Objection to Development Application SSD-93020230 at 40–48 Redan Street, Mosman

J. Breakspear BLArch, MSc (Environmental Planning)

2 PLAN Driveway Plan
1:250

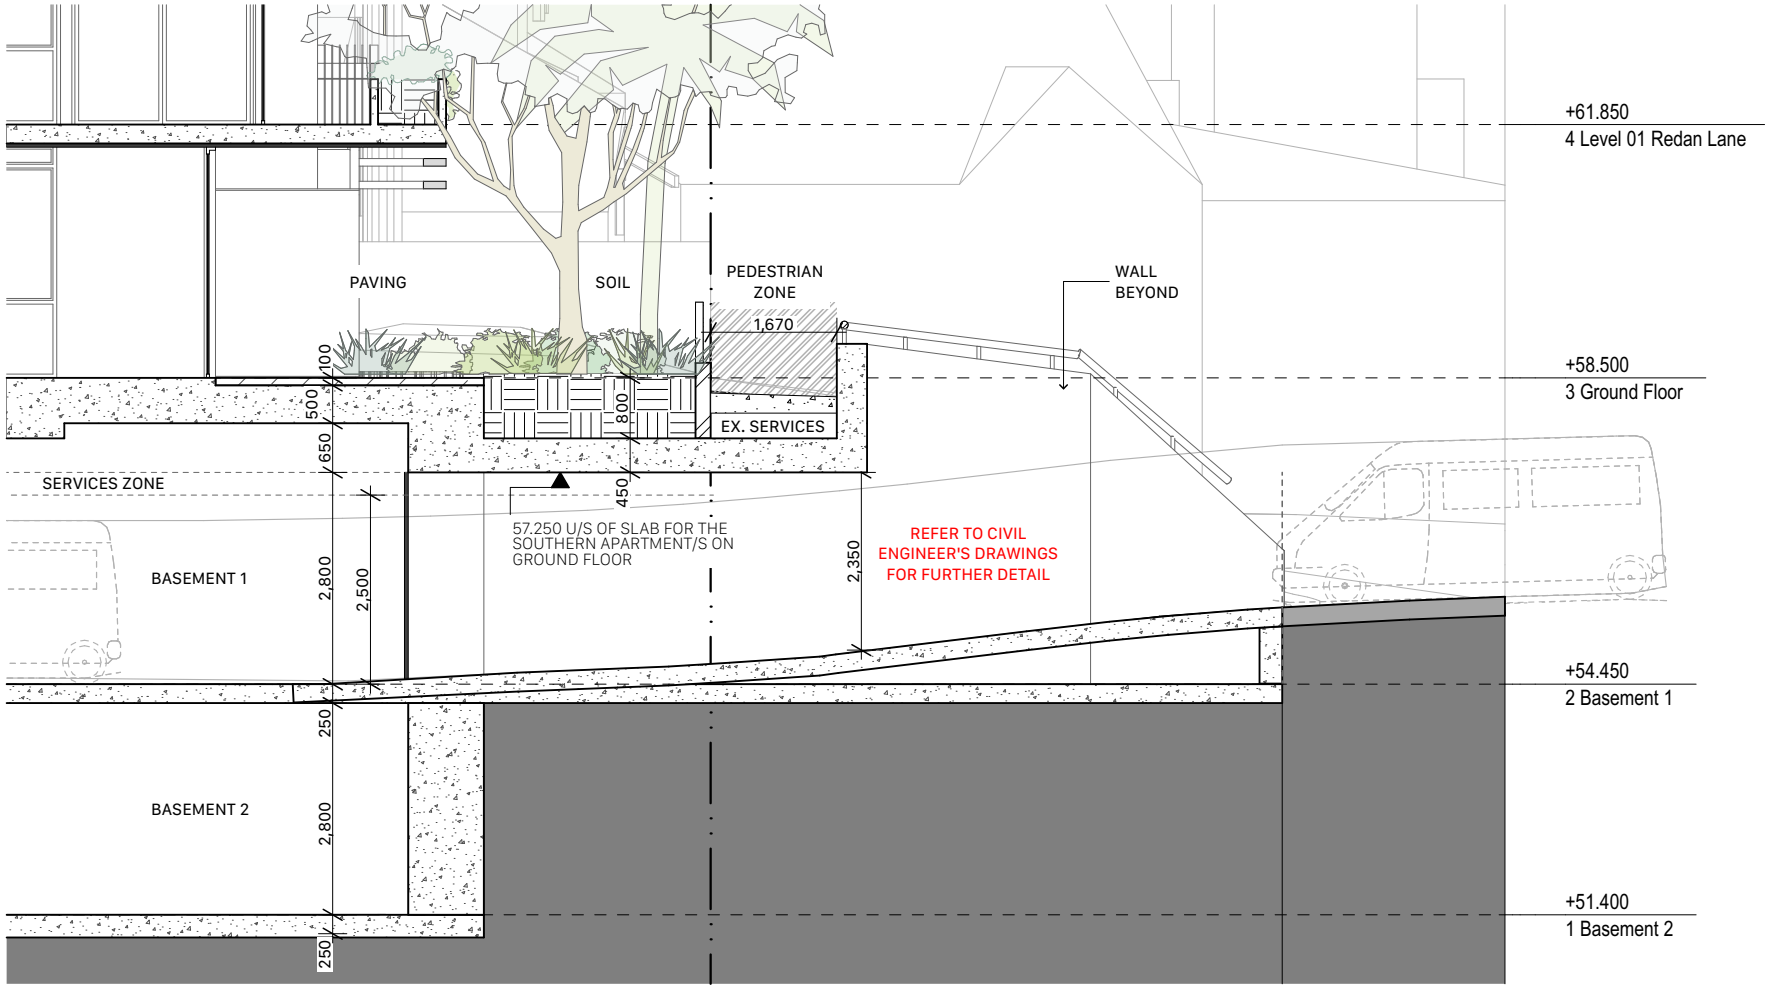
The entire vehicular access relies on the proposed illegal access assumption of a major vehicular crossing along the eastern frontage from heritage listed Redan st. Access from the rear narrow highly constrained Redan Lane would not be feasible for the proposed multi storey basement parking of 106 carparking spaces and services and would create major flooding issues in high rainfall events for any basement car parking as has been observed in a new development further up along the lane.

This assumption is very disturbing as Mosman Council does not allow any vehicular access from Redan st due to its historic verge and the very beautiful scenic quality the whole high side of Redan st on both sides of Almora st provides as a high quality pedestrian experience with no driveway disturbance, leafy verges and Sydney garden spp and as a backdrop for the numerous heritage listed houses along Redan St. The Redan St Council verge also provides habitat for native bandicoots and many bird species. We often see the Bandicoots
